**DELEGATED DECISION FOR APPLICATION FOR CERTIFICATE OF  
LAWFUL DEVELOPMENT**

Reference no.: 2025/CL/93071/W

Site: Glenelg, 53, Long Lane, Honley, Holmfirth, HD9  
6EB

Description: Certificate of lawfulness for proposed siting of  
caravan

**Block Plan
1:500 @ A3**

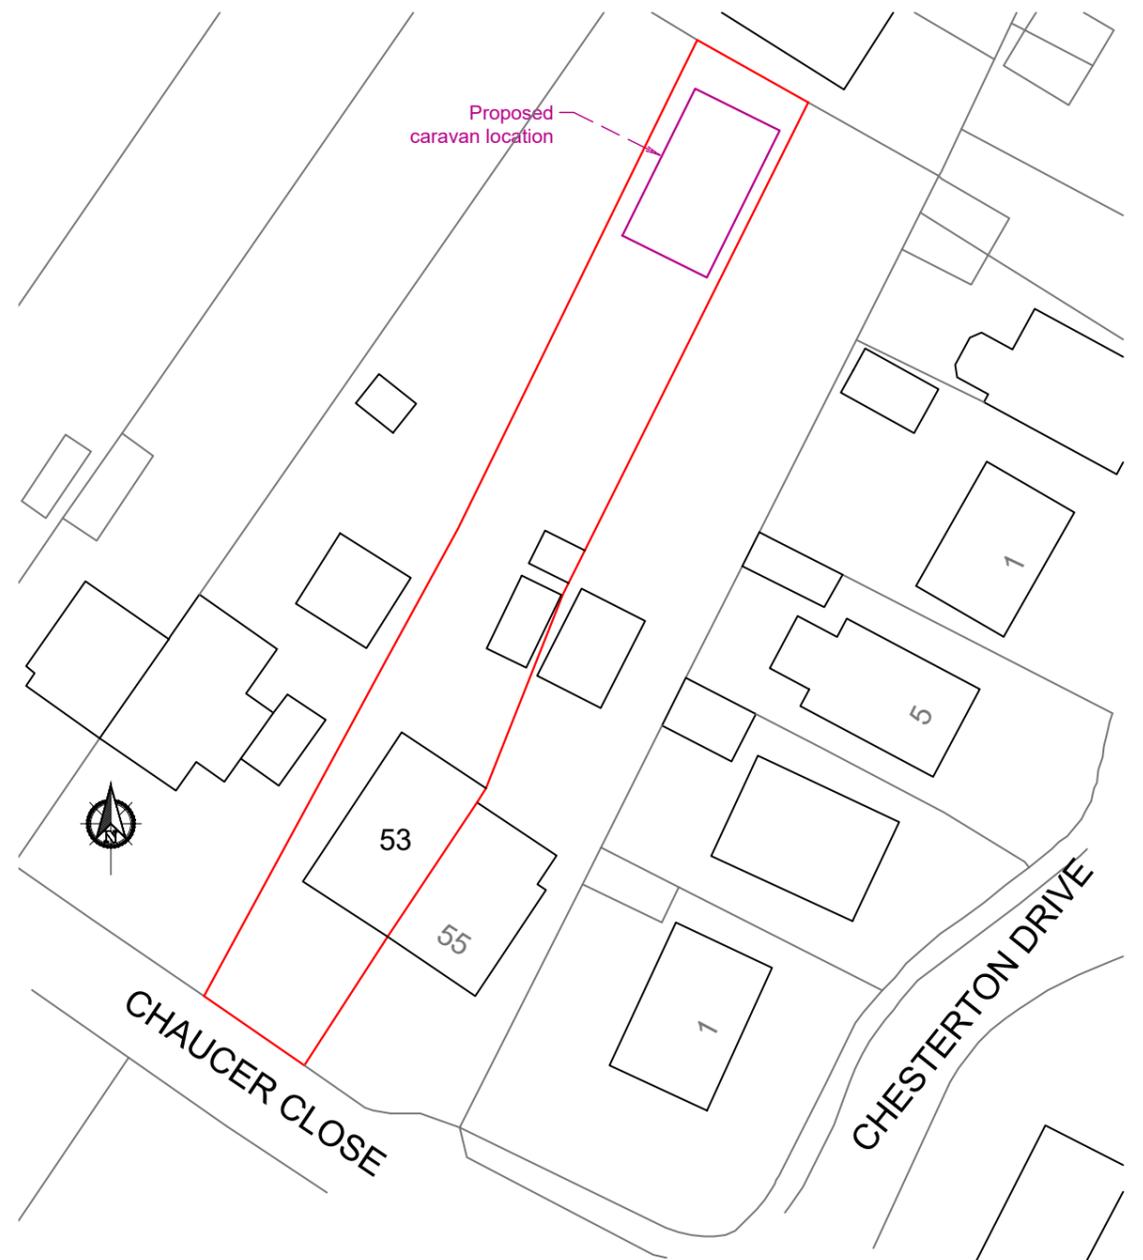
3.2 The submitted plans indicate that the caravan would be located within the northern section of the amenity space within the rear garden however it is noted that within Section 4.3 of the Planning Statement that the *'location could be changed at any time and for any reason, as long as it remains within the residential curtilage and the use / functional relationship with the main dwellinghouse remains the same.'*

Caravan Details

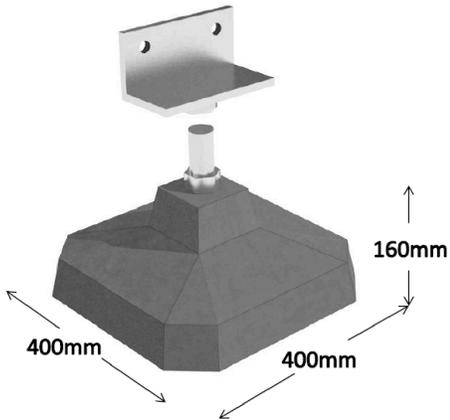
3.3 In terms of the size of the caravan, Section 4.6 of the Statement indicates that the unit is 11.6m long and 6.6m wide with no overall height submitted. Whilst there is no reference to appendix B within the body of the planning statement, the content section refers to appendix B as proposed caravan unit details. The isometric plans indicates a unit containing three bedrooms, kitchen, living areas and what appears to be toilet and washing facilities. Appendix B also shows a structure lifted by a crane and an extended structure placed on supporting pads. However, paragraph 4.3 within the body of the statement suggests the unit will be built out of a shipping container with pop-out elements that

increase its overall size. This appears contrary to the wider argument that the unit is a caravan or would be the same as the unit shown in appendix B. Moreover, paragraph 6.2 of the statement confirms the drawings, plans and site location are for reference only and that the actual unit may change and at any time thereafter. Overall, it is not clear from the statement what the caravan consists of. The information is imprecise and seems to suggest that any size of caravan is proposed.

- 10.4 The submission provides no clear evidence to understand the size, nature and construction of the unit without a significant degree of ambiguity. Whilst the statement refers to a size of a shipping container with "pop-outs" and appendix B shows details of a unit, paragraph 6.2

makes it clear these are general details and “final design, dimensions and location may change before installation”. Moreover and whilst a photograph of a unit being held by a crane is provided in appendix B, the submissions do not show how in this instance the unit would be capable of being moved with evidence of structural capabilities that the unit can be lifted without additional support. There is also no evidence to demonstrate the unit is capable of being accessed and lifted from a location within the rear garden of the property. Under these circumstances and as the onus is on the applicant to demonstrate the proposed work/use if lawful, it is considered the applicant has not provided sufficiently clear and unambiguous evidence to show the specific unit is as a matter of fact and degree a caravan. The information is simply too vague to undertake a proper assessment of whether or not a structure of indeterminate size, nature, design, construction and capability of being moved.
